Office of Water

5 August 2011

Exhibition of Environmental Assessment Newcastle Gas Storage Facility (10_0133)

I refer to your letter of 14 June 2011 and advise that the NSW Office of Water (NOW) has reviewed the Environmental Assessment (EA) for the project proposal and provides the following advice and recommended conditions of approval on the basis that the existing legislative provisions under Part 3A of the *Environmental Planning and Assessment Act 1979* apply to this proposal.

FIGURE 3

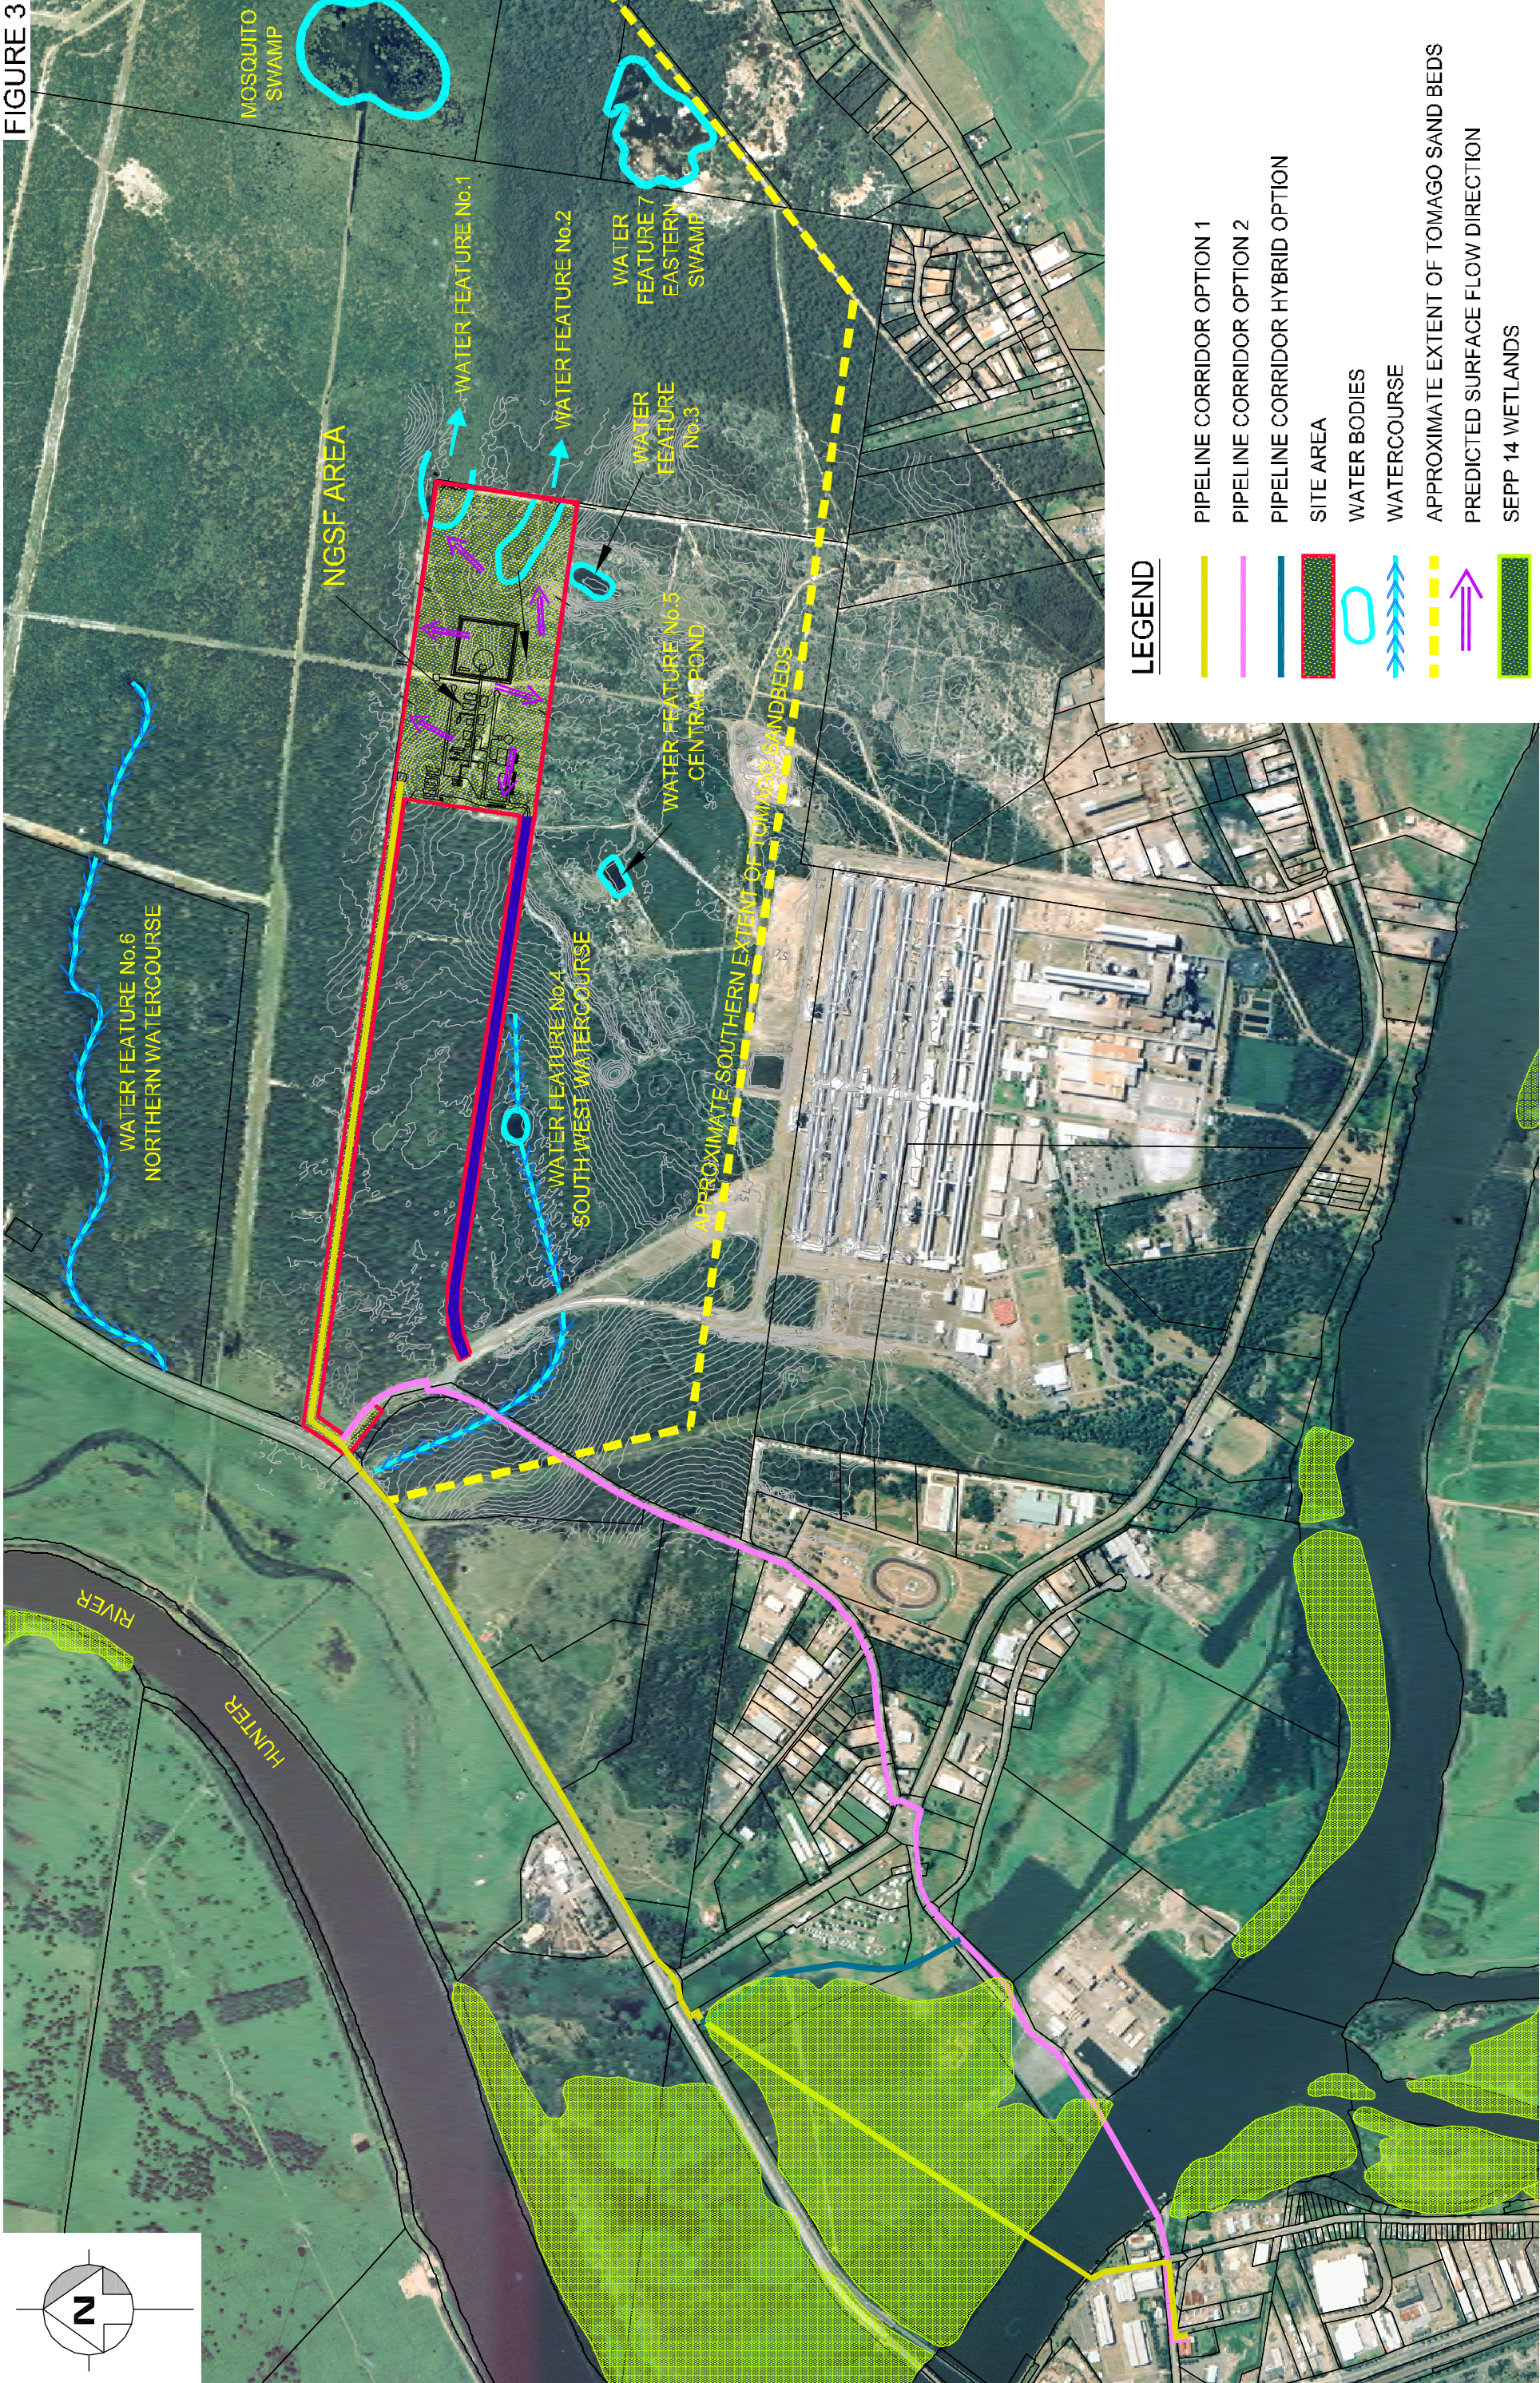
Firstly, NOW is concerned that the EA does not assess the potential impact of the gas pipeline crossing Water Feature 4 or provide that the crossing will be undertaken in accordance with NOW's *Controlled Activities: Guidelines for Watercourse Crossings*.¹ Although Part 3A Major Projects are currently exempt from requiring a controlled activity approval (section 75U of the *Environmental Planning and Assessment Act 1979*), it is important that crossings are consistent with these guidelines to ensure that no more than minimal harm will be done to waterfront land as a consequence of the construction of the crossing.

FIGURE 5

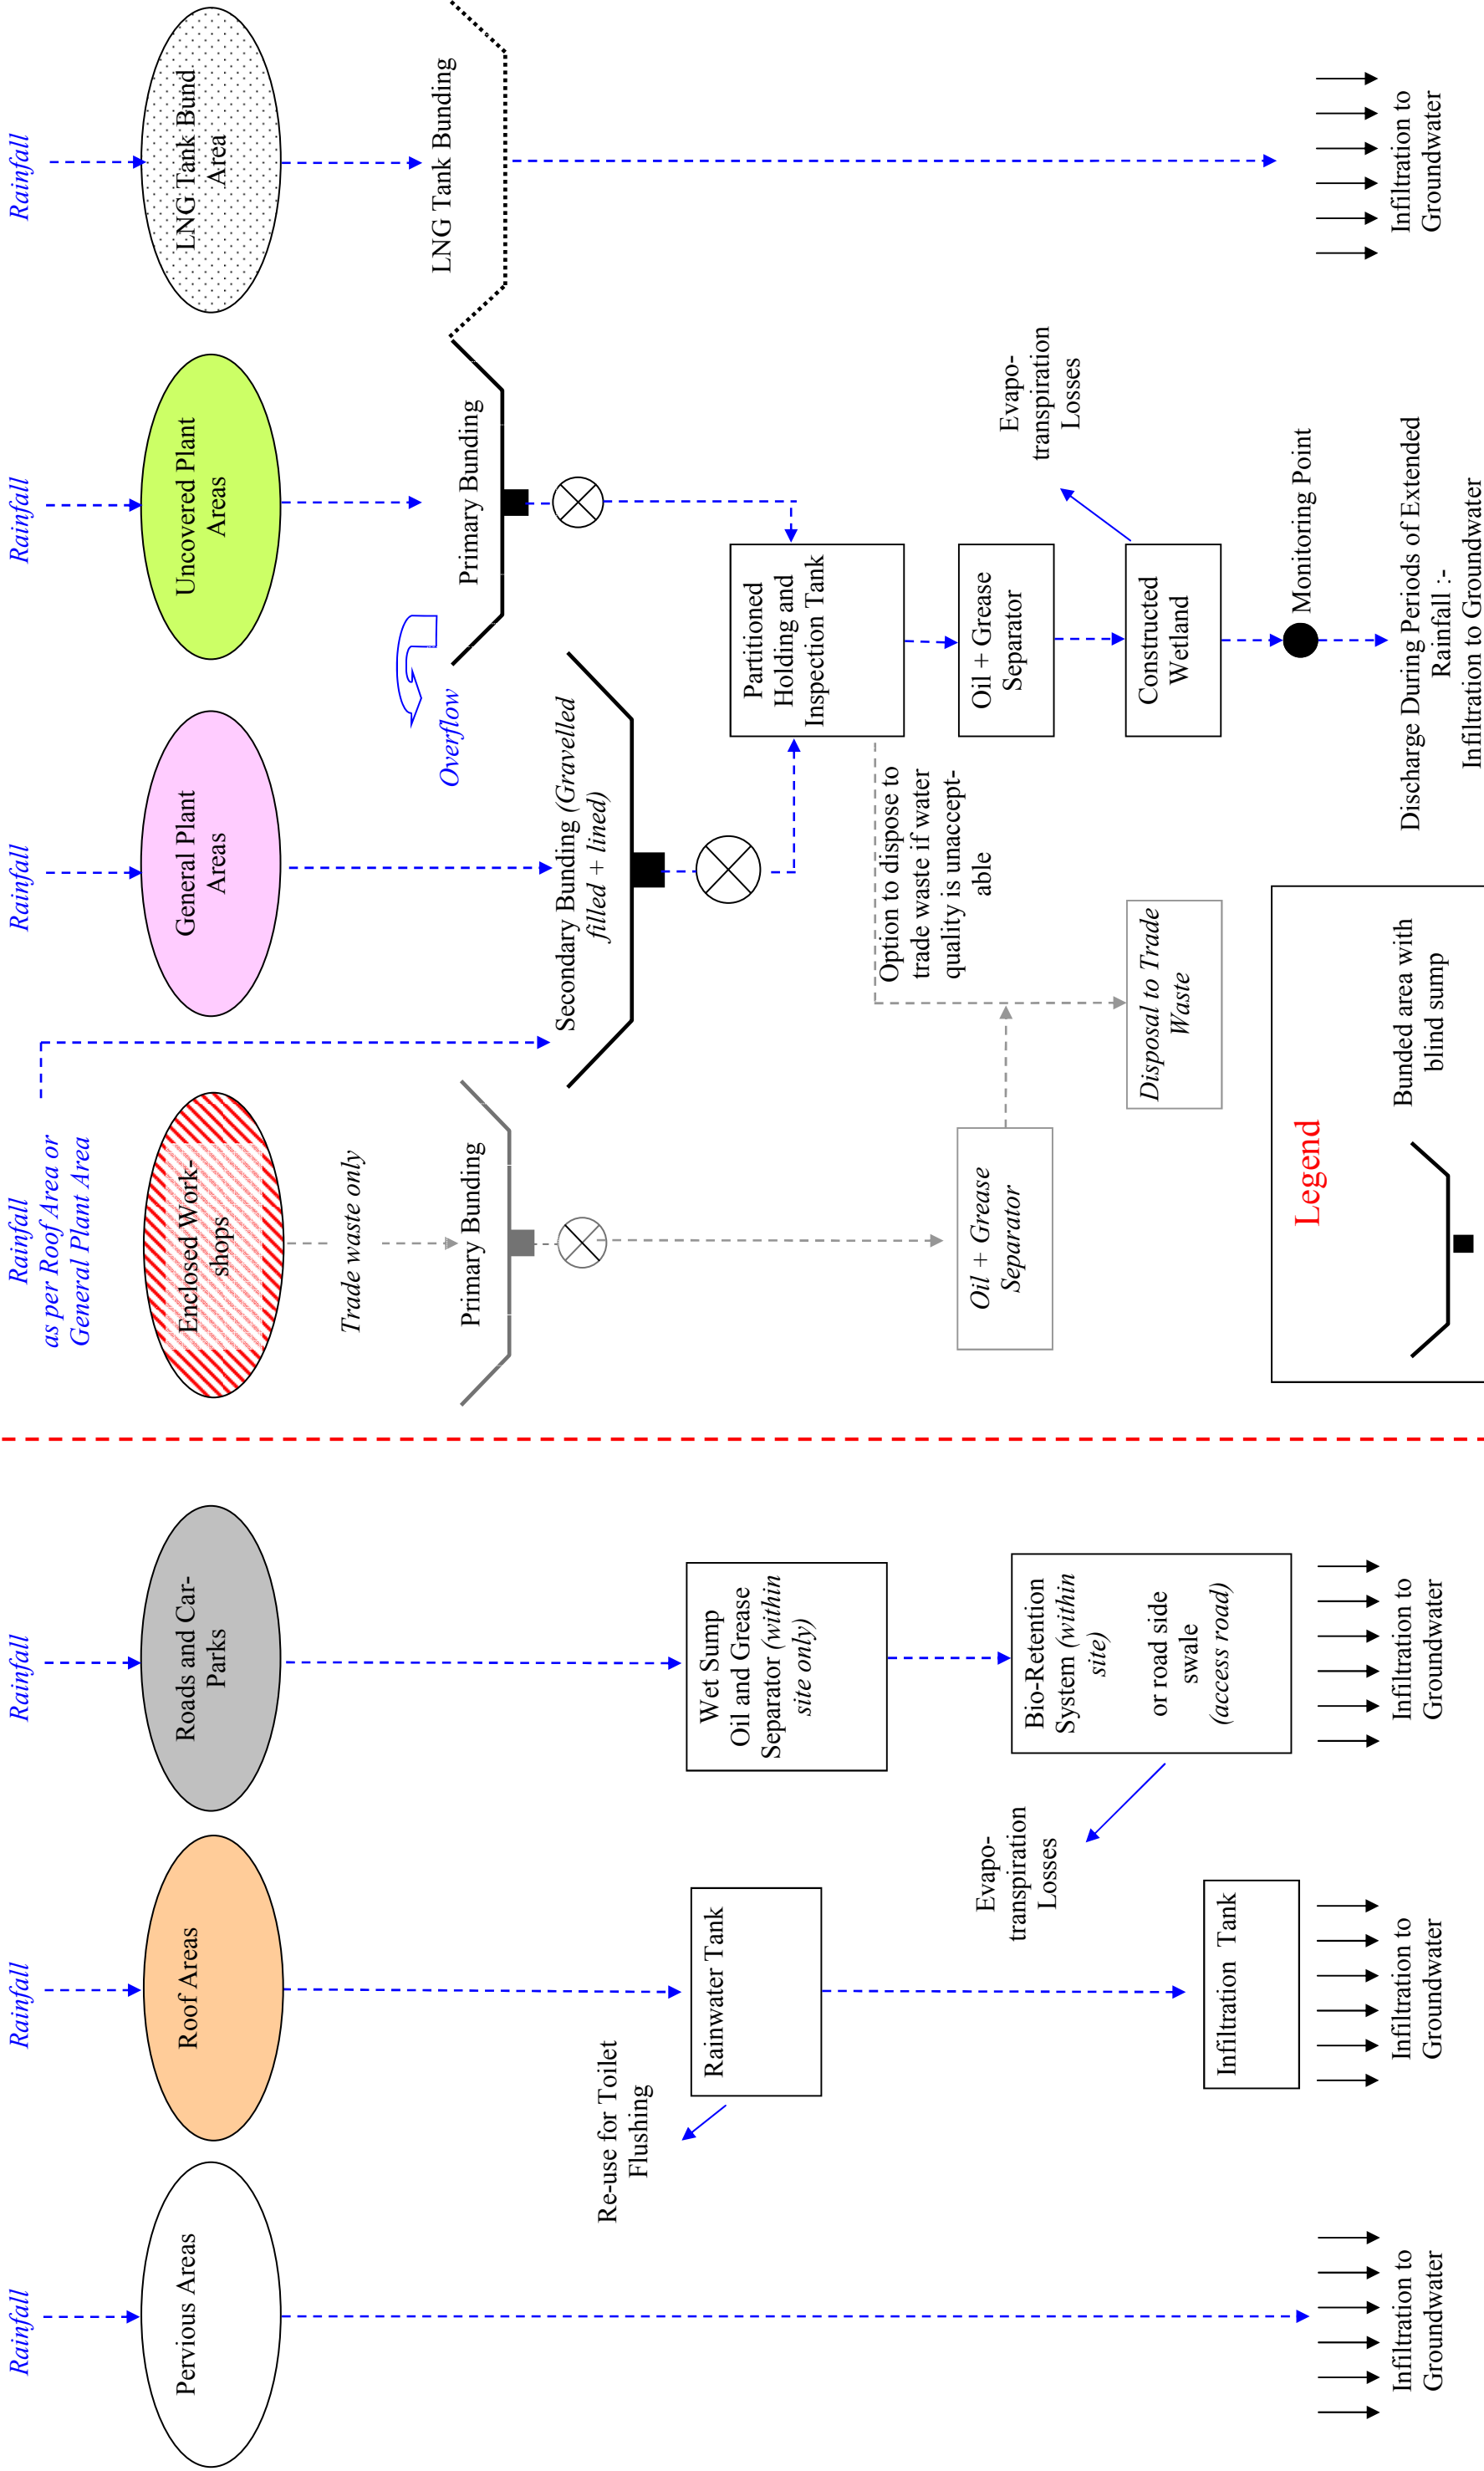
Secondly, NOW is concerned that the EA does not demonstrate the capability of the constructed wetland/holding pond to deal with the volume of runoff from the uncovered and general plant areas. This issue was raised by NOW in advice regarding the adequacy of the EA and it is not clear in the current version of the EA that this issue has been addressed. The constructed wetland/holding pond must be designed so as to ensure its capability to deal with the volume of runoff from the uncovered and general plant areas.
